**Ref No:** F2020/00664

Application No: SSD-10822510

**Re: Randwick City Council submission on the State Significant Development SSD-10822510 – UNSW Health Translation Hub (SSD-10822510)**

8 June 21 - 4pm
CD305 SCALE: 1 : 2000

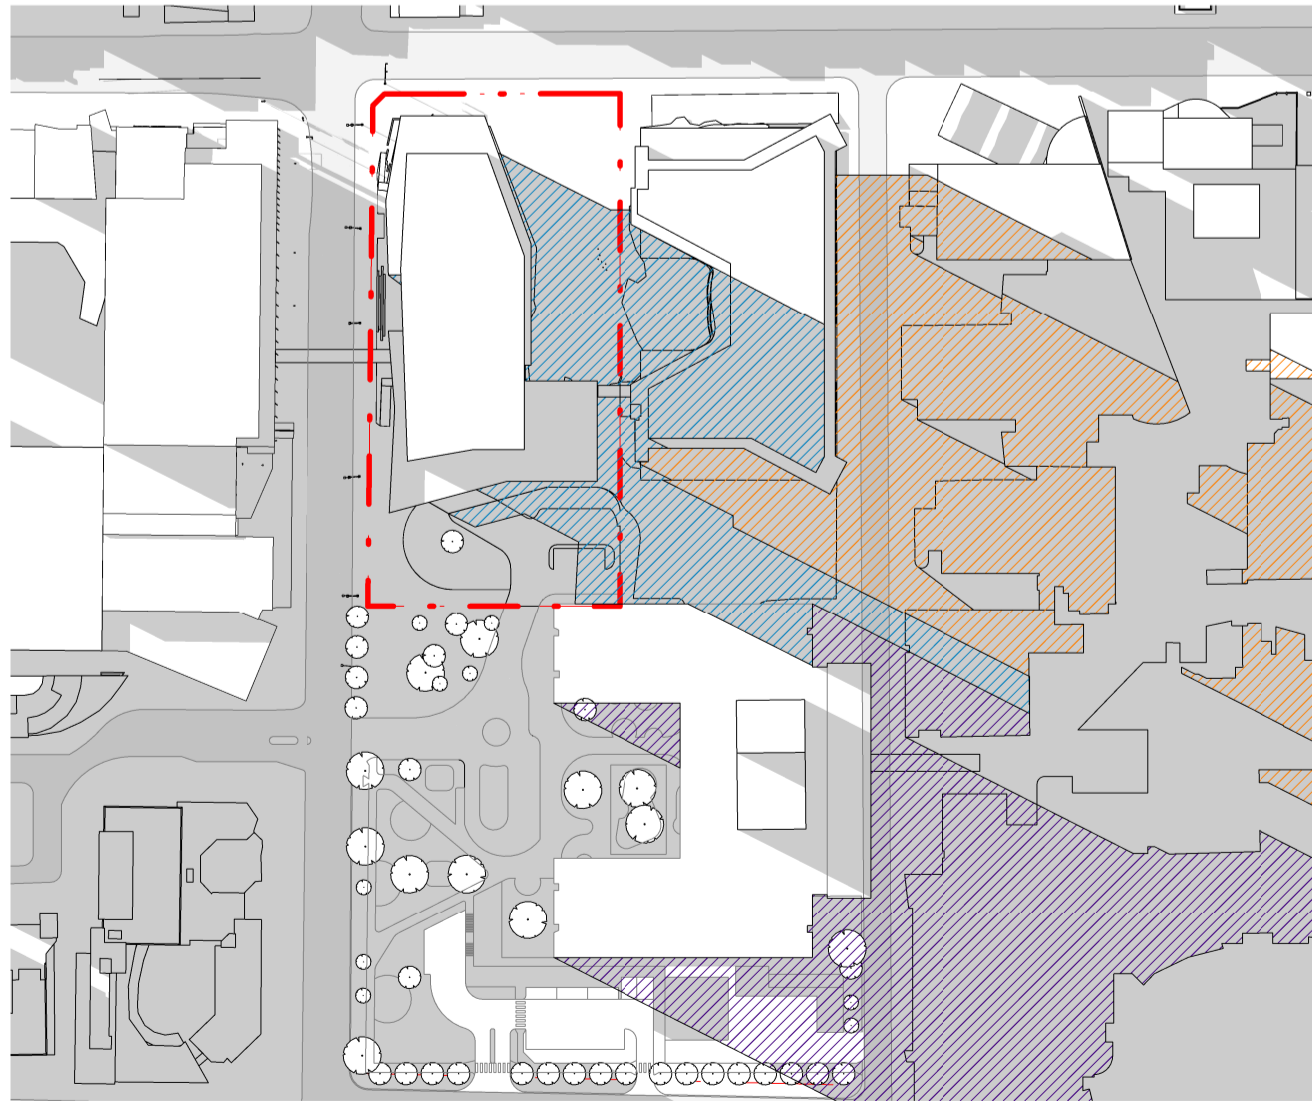
6. The Integrated Acute Services Building (IASB) forecourt and main hospital vehicular drop-off/pick-up has the potential to provide an important new green space along Botany Street for the enjoyment of Randwick Hospital, the UNSW campuses, and the broader Randwick community. It will be important to provide a quality landscaped experience that is not unduly overshadowed in the winter months by the upper levels of the proposed UNSW HTH building to the north.
7. It appears that the current southern leg of the UNSW HTH building will overshadow the Children's Hospital emergency vehicular drop off loop and pedestrian waiting area, as currently configured, for most of winter months.
8. The shadow diagrams provided are limited, addressing only the early morning, midday and late afternoon. Hourly shadow diagrams at the 21 June should be provided to assess solar access and amenity.
